**Norwich Cycling Campaign  
Verbal Submission  
On-line Session 20 August 2021**

## **6 The B1140 overbridge**

We refer to drawing number HE551490-GTY-EPE-000-DR-CH-3007 /TR010040/TR010040-000480- .4 Rights Way Access Plan 20 202

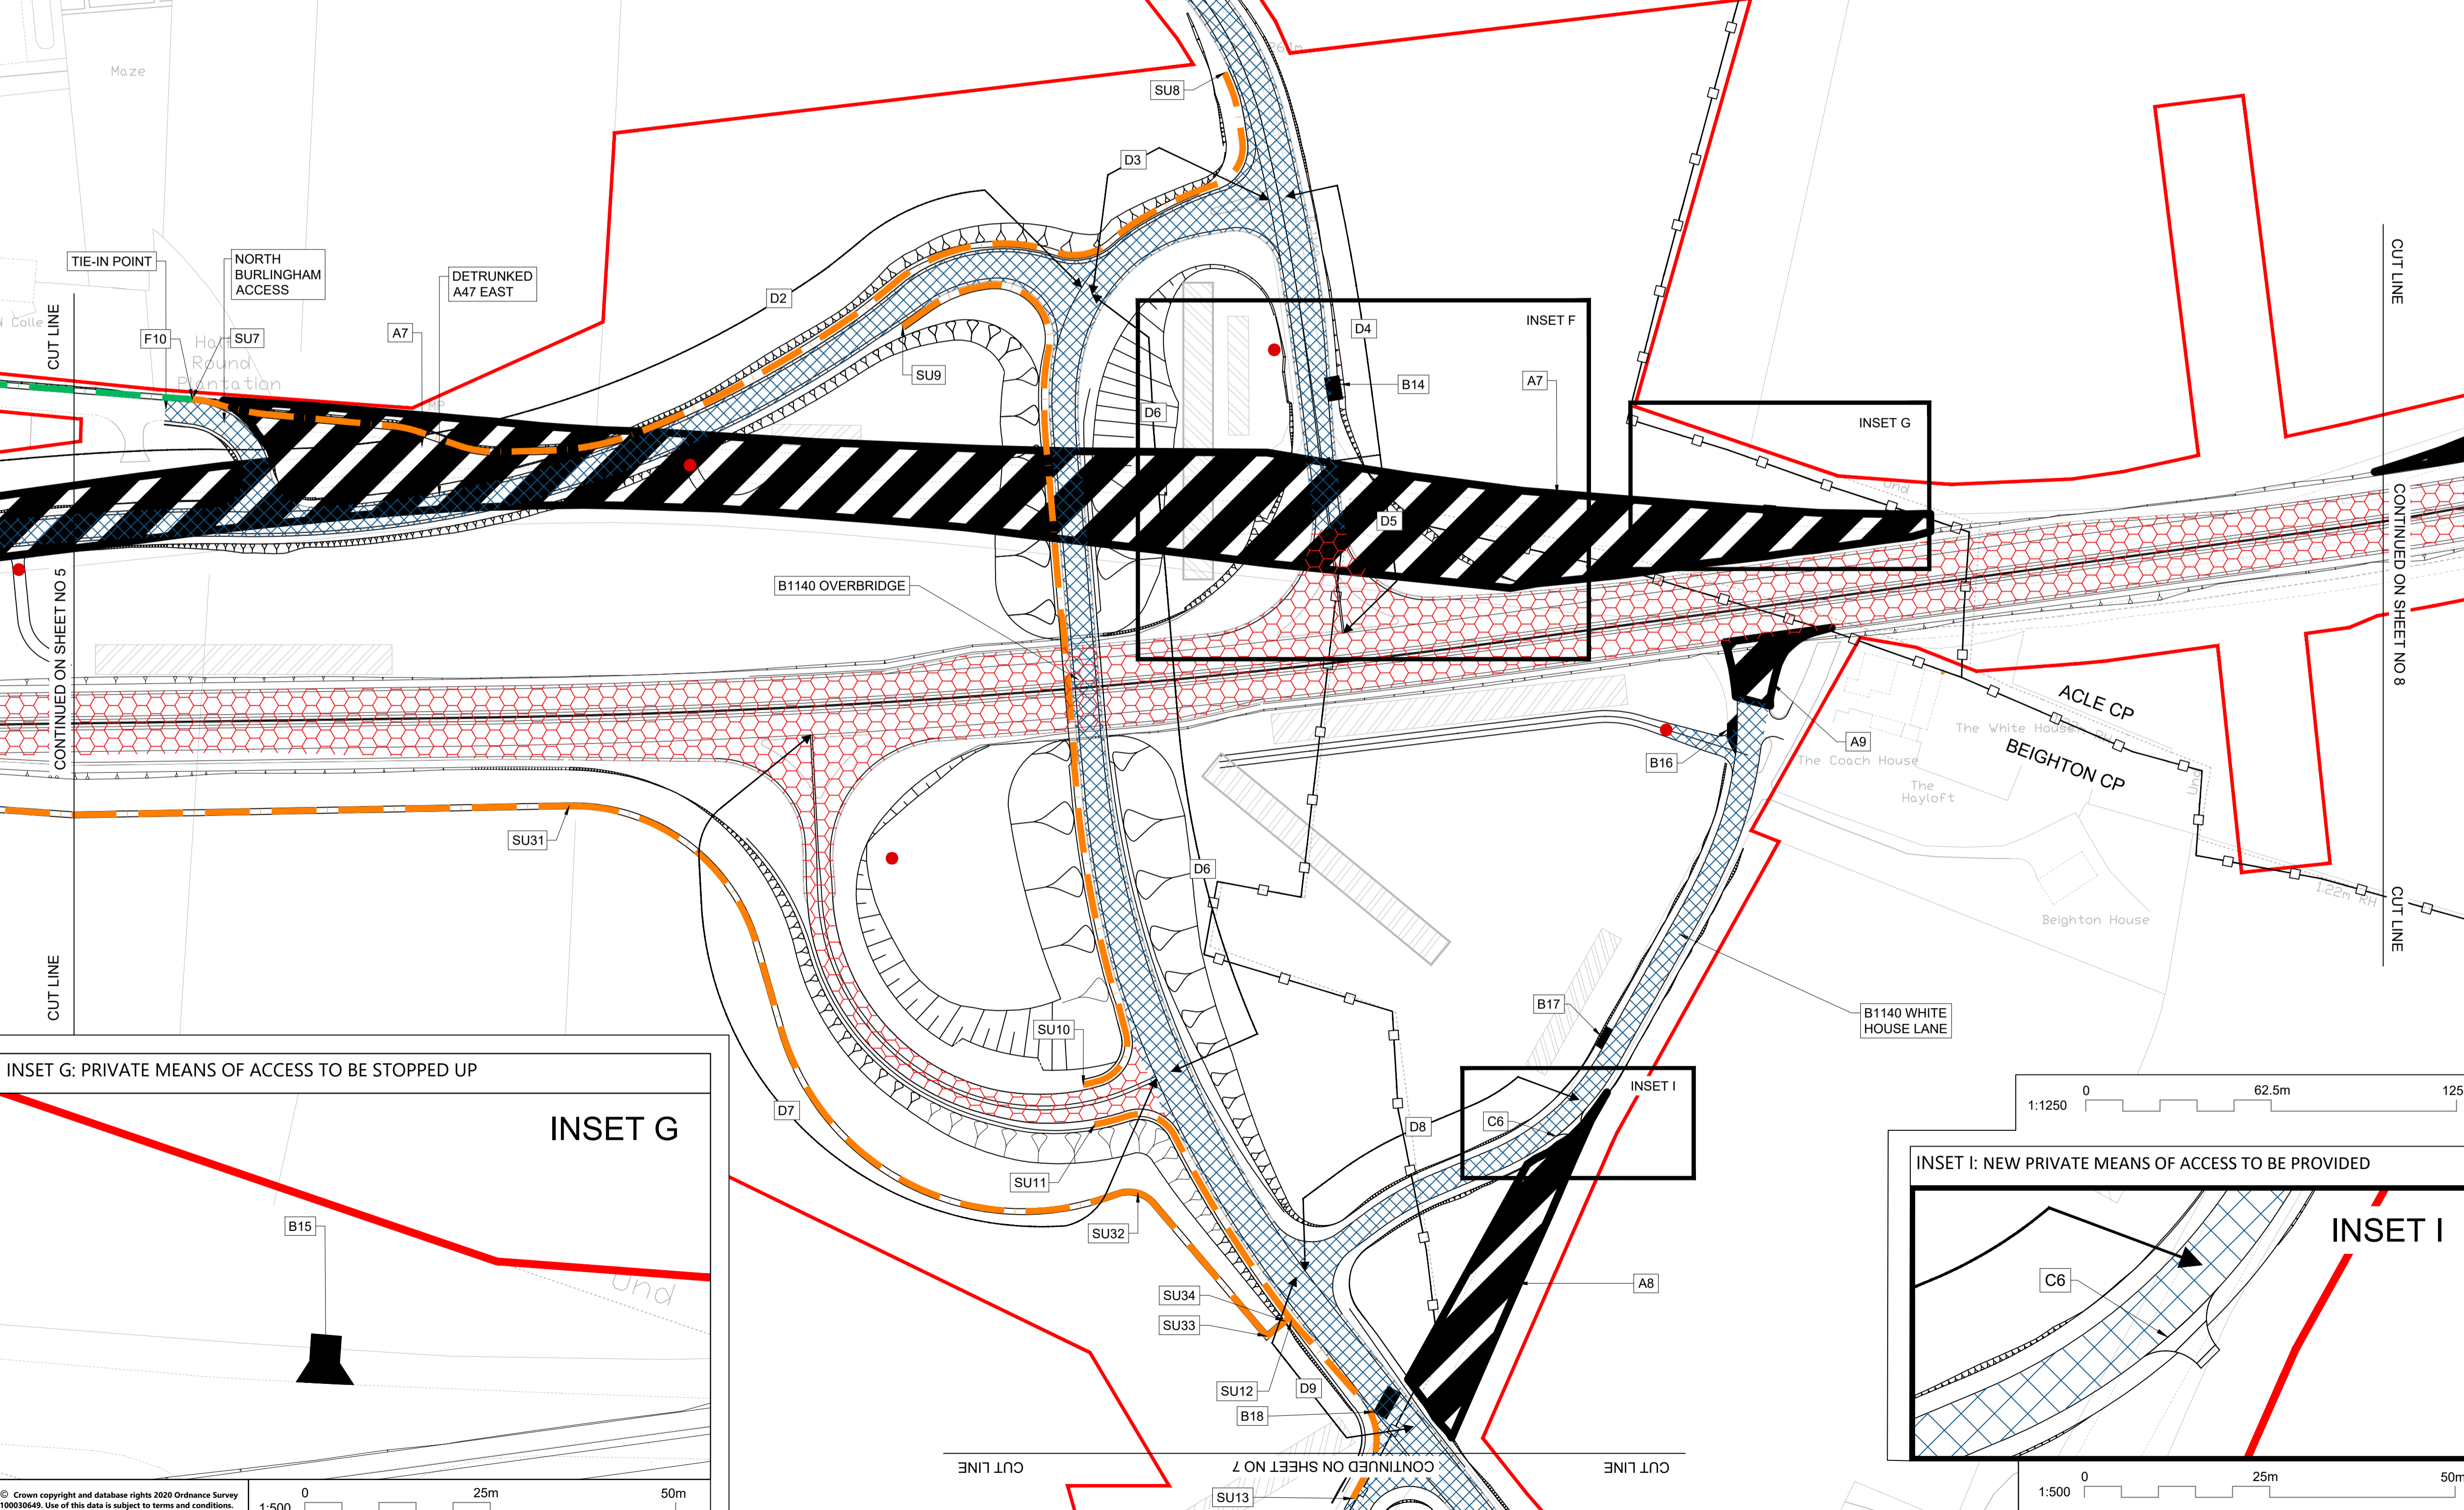
A “New Cycle Track” is shown from North Burlingham Access, SU7, to SU7 on Cox Hill Road, B1140. This is referred to by HE as a route to be used by pedestrians and cyclists to access Lingwood and should therefore be referred to as a “shared-use” path.

It is described as 2 metres wide, the minimum width described in Table E/3.1 page 11, CD 195. Is this appropriate for cycles, buggies, electric delivery cycles, and disability scooters?

In view of the combined use, and the importance that Highways England have attached to this facility, DMRB CD 353, Design criteria for footbridges should apply.

There is also mention of some kind of segregation: the design, purpose and function is not clear. If this segregation is to provide physical protection from HGVs it will have to be substantial. If it is merely a token design feature to provide assurance to walkers and cyclists then it is probably a waste of money. Either way any form of segregation is an admission by HE of the danger, real and perceived, of this plan.

No information has been provided regarding the gradient; CD 353 Design criteria for footbridges, 5.8, page 14, specifies 1/20.

No information has been provided on this crossing.

No information has been provided on this crossing. This will be the major route for HGVs accessing and leaving the B1140 for Cantley, as well as traffic to and from Lingwood, joining and leaving the new A47. See Appendix A, on our submission, for dangers of HGVs. (TR010040/TR010040-000446-D2-Norwich-Cycling-Campaign)

This will dump cyclists and pedestrians on the B1140 to share the space with up to 1,000 HGVs and other vehicles per day. (LTN 1/20, Core Design Principals, 4.2.4 Coherent)

This design breaches all of the five Core design principles set out in Section 4, pages 30 and 31 of LTN 1/20 (Appendix B):
